From: Marlow, Angela (NE) [REDACTED]
Sent: 17 October 2016 16:29
To: Simon Davis
Cc: McKernan, Patrick (NE)
Subject: Advice to Arun on condition for Pagham spit proposal

Thank you for sending though the proposed conditions (in document Draft Planning Conditions v5 280916 (3)) on the 28th Sept 2016 and the comments from ABPmer, below is our advice which I hope you will find helpful with a focus on conditions 5, 6, 7, 8, 9 & 10, which you asked us to consider.

Location Plan Showing the Application Area (including access routes)

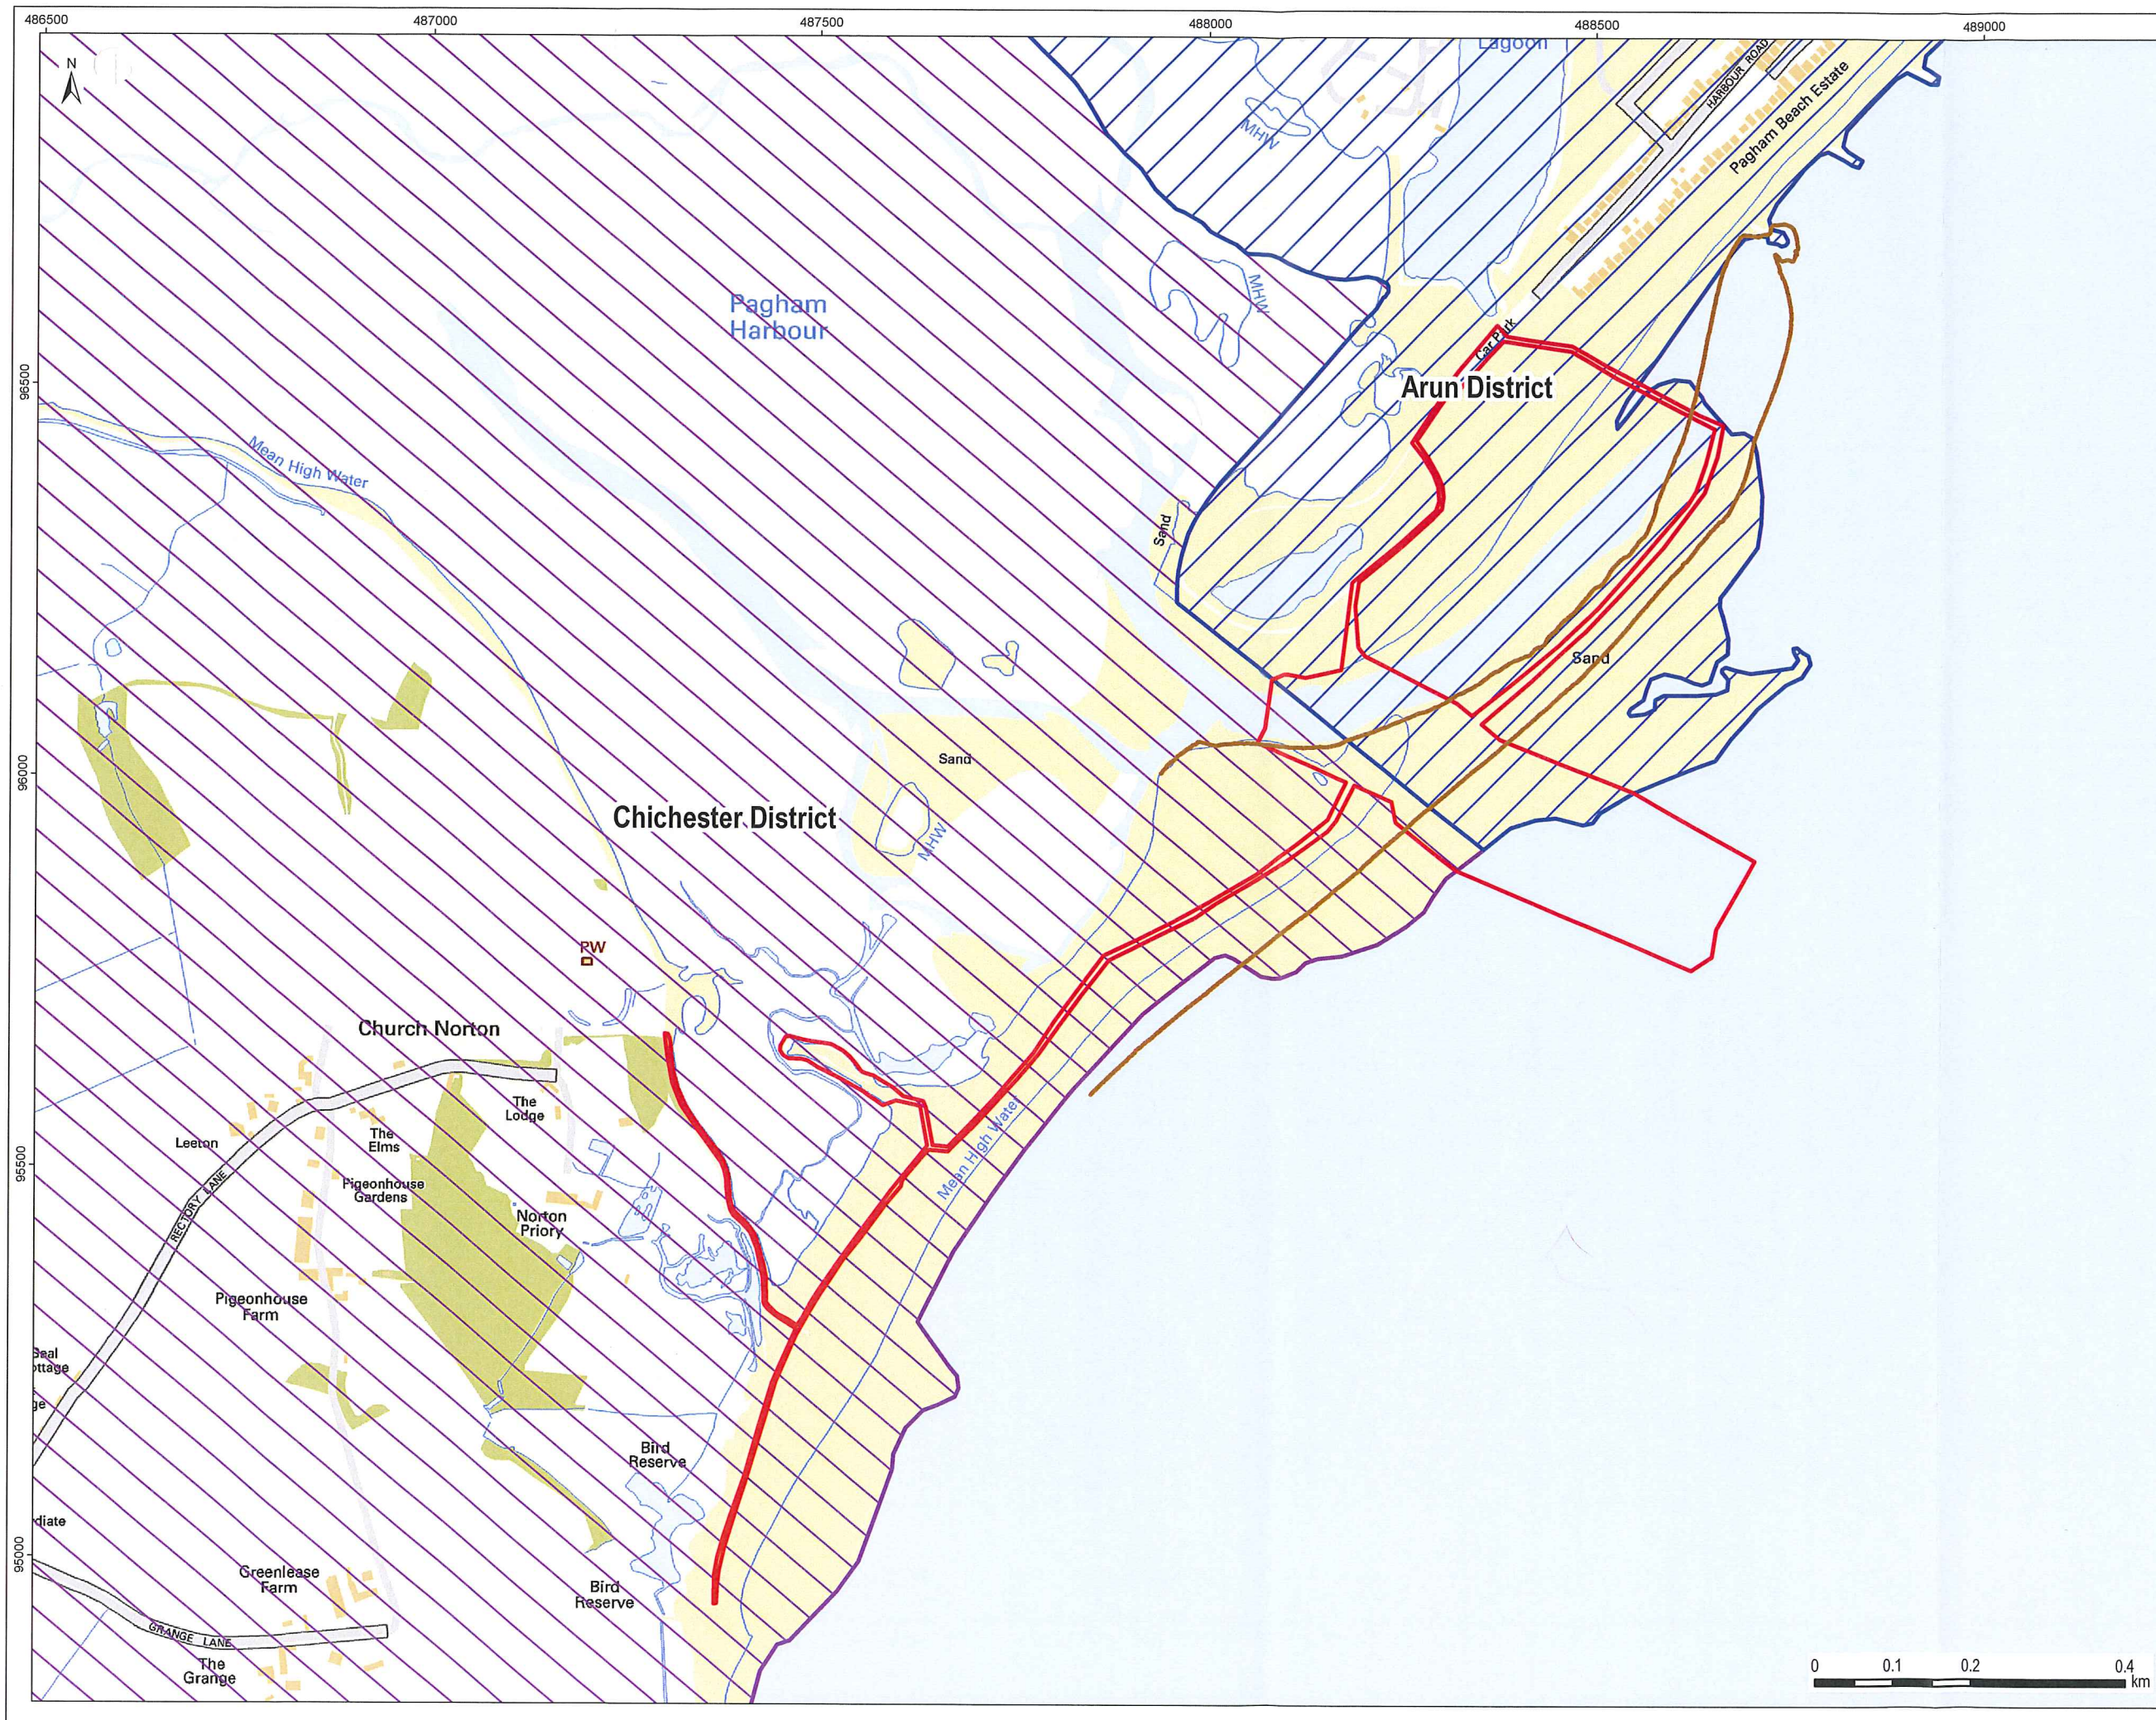
Final access routes can be agreed in the construction management plan and should be in line with the proposed routes in the application via the Pagham Frontage. An emergency refuge on the Church Norton side of the spit can be agreed.

Block Plan Showing the Breach and Infill Area

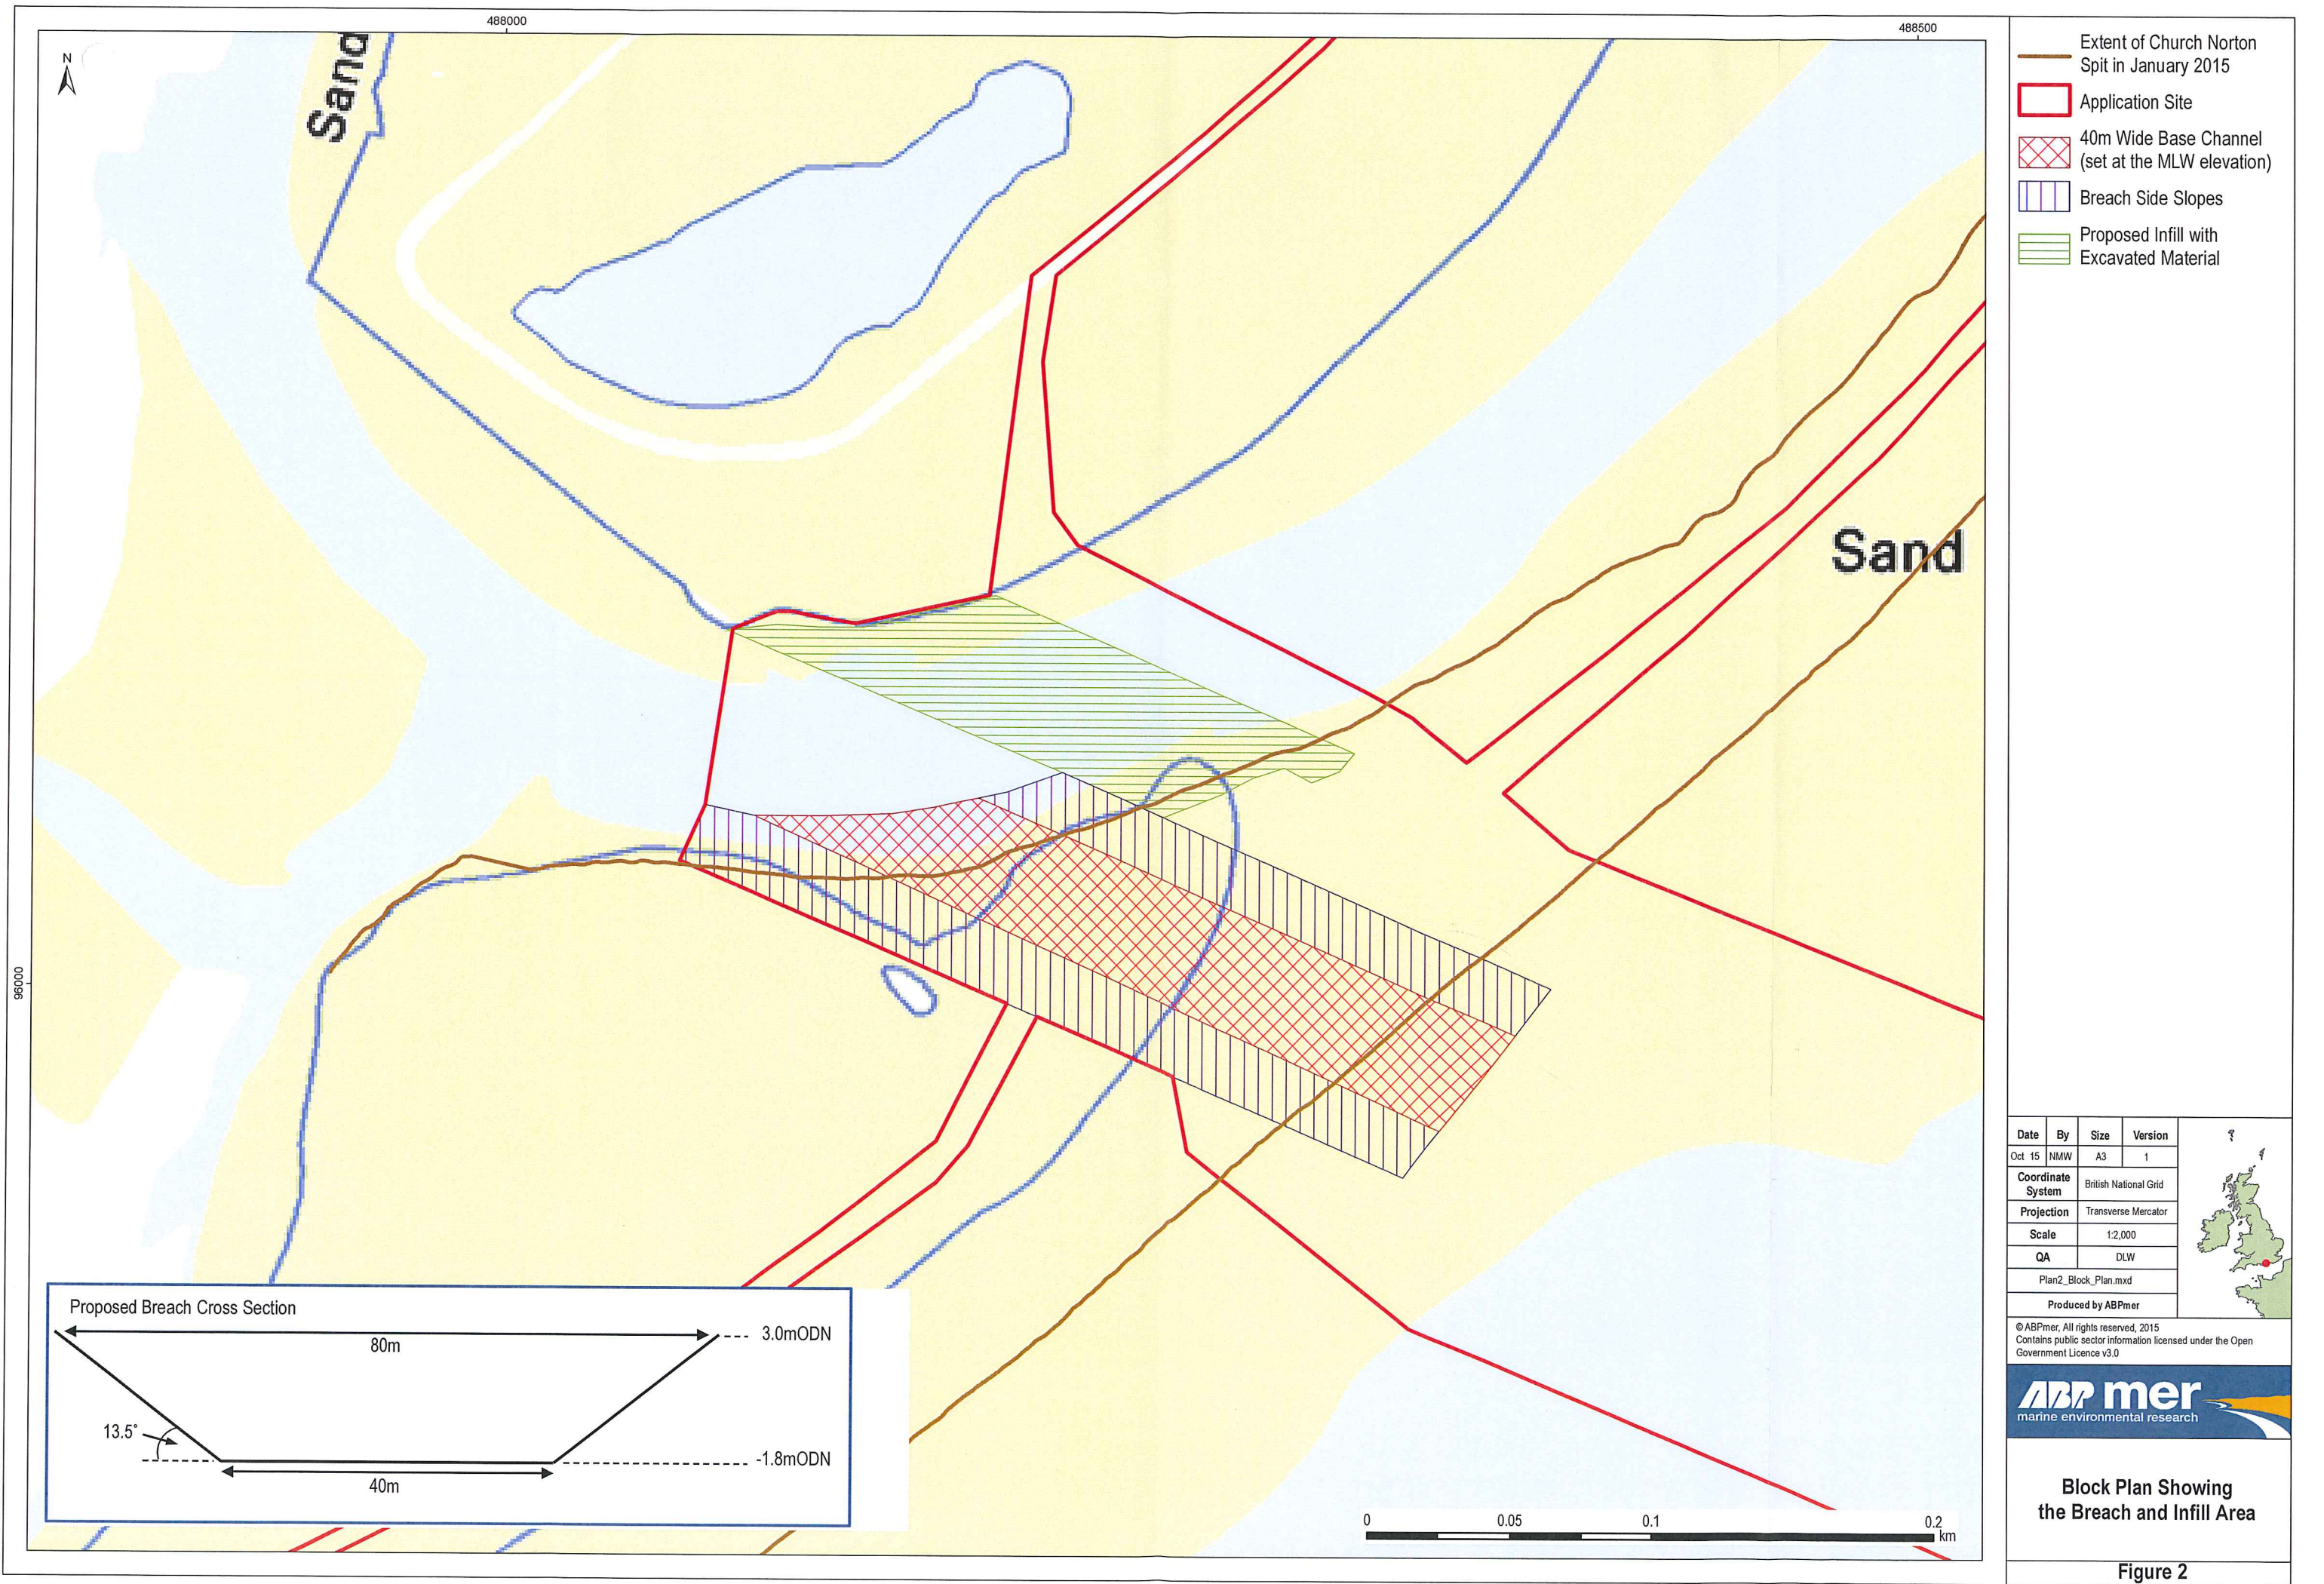
We recognise that it may be difficult to ensure that the tern island is permanently isolated in all tidal states, and welcome ABPmer's intention to use every effort to shape the landform sensitively and isolate the island. We have discussed this with the RSPB and we are satisfied that sufficient measures will be in place to ensure the island is kept predator free, through the use of predator fencing, and that the channels around the island will be hydrodynamically connected to the tidal waters either side of it with a view to isolating the island at most states of the tide.

With regards to the timing of construction for the little tern island, we advise that this habitat needs to be in place in time for the breeding season which follows the breach being made, so that it is ready to be used as compensatory habitat. Our understanding is that the island will be constructed from the material arising from the breach being cut, and that therefore it will be put in place as part of the completion of the works.
